SSD 35538829: PARRAMATTA METRO OVER STATION DEVELOPMENT

SUBMISSION

STATEMENT OF OBJECTION

Figure 2-4 Tower setback plan

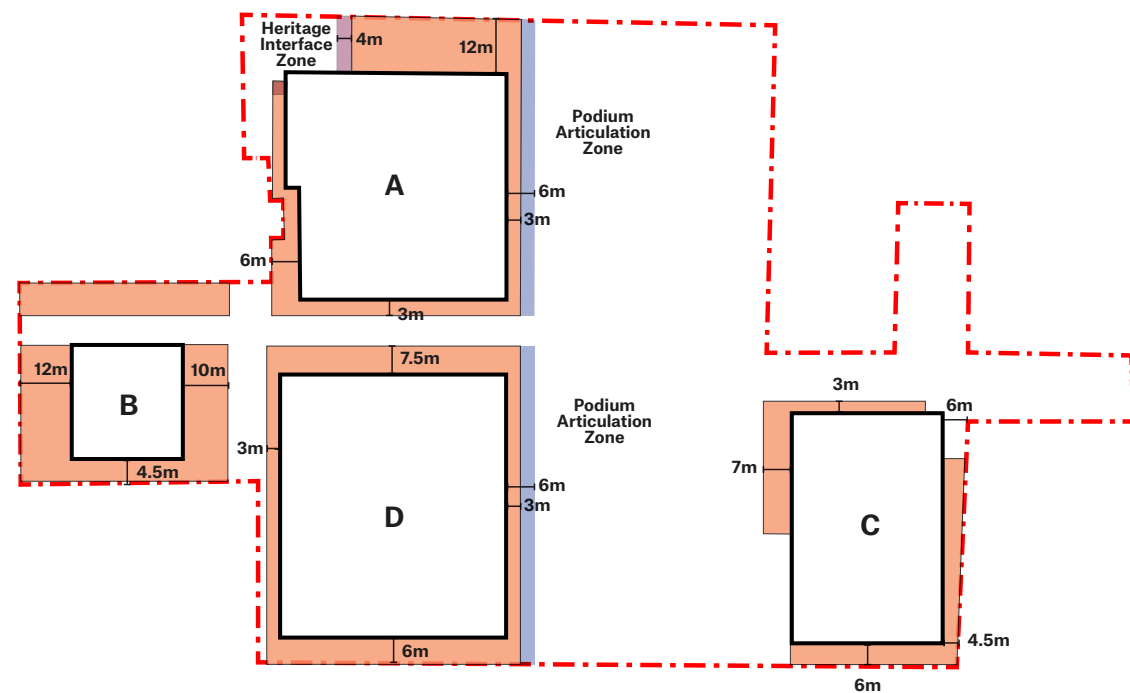
Building A separation with properties to the west at Church and George Streets – The western edge of Building A has insufficient separation with the adjoining sites to the west. It is not clear in the documentation how this would be resolved with existing buildings and future development opportunities.

The Concept Application, however, is entirely inconsistent with the DCP separation requirements. This has been confirmed by Turner Studios, who mapped the envelopes over the Metro Site and the neighbouring properties to the west of Building A. This analysis shows that to achieve an 18 m separation, this will be applied to our clients and potential development partners' land. The impact of this change is:

- Our client will lose of at least 84 m², equivalent to 2,285 m² over the height of the building and having a significant cost implication to development feasibility.
- Sydney Metro will gain circa 235m² which, when extrapolated over the height of the building, represents a significant additional yield on metro land.

- Is inconsistent with the ADG separation objectives and requirements
- Is inconsistent with the City of Parramatta DCP minimum building separation of 18m
- Does not equally apportion the separation between Building A and the site to the west as required by the ADG and the DCP
- Places the burden of a tower being able to be viewed in the round on our client's site only

- Building A be redesigned to prevent it from stealing floorspace from our client's neighbouring site.
- The floorplate of Building A be reduced to facilitate the equitable sharing of building separation of at least 9m on each respective site.
- Building A be redesigned with a smaller floorplate to fit better into its context and display a harmonious relationship with Church Street and surrounding development.

Accordingly, this submission outlines Dehsabzi Enterprises Pty Ltd strong objection to SSD 35538829. It requests that the Building A envelope be reduced to provide an equitable sharing of the separation between buildings (a minimum of nine metres on each site).
